Application No: LU/27/22/HH
Site Address: 103 Griffin Crescent Littlehampton BN17 7LH
Description of works: Erection of two storey side extension following the demolition of single storey detached garage.

Thank you for your internet representation made on 28th February 2022 which has been recorded as an objection with the comments as follows:

PROPOSED SIDE ELEVATION

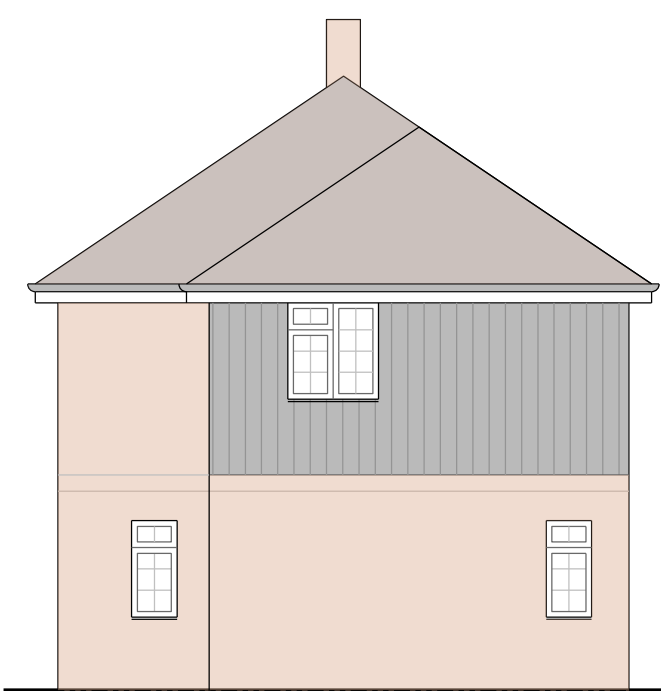
The Side elevation. Upstairs/first floor ,the window 4 metres closer to my property so it would able to see right easy into to my first floor window on my property so i think its taken so of my Privacy away .i would have No objection for the window,if it has pattern or frost glass in it.
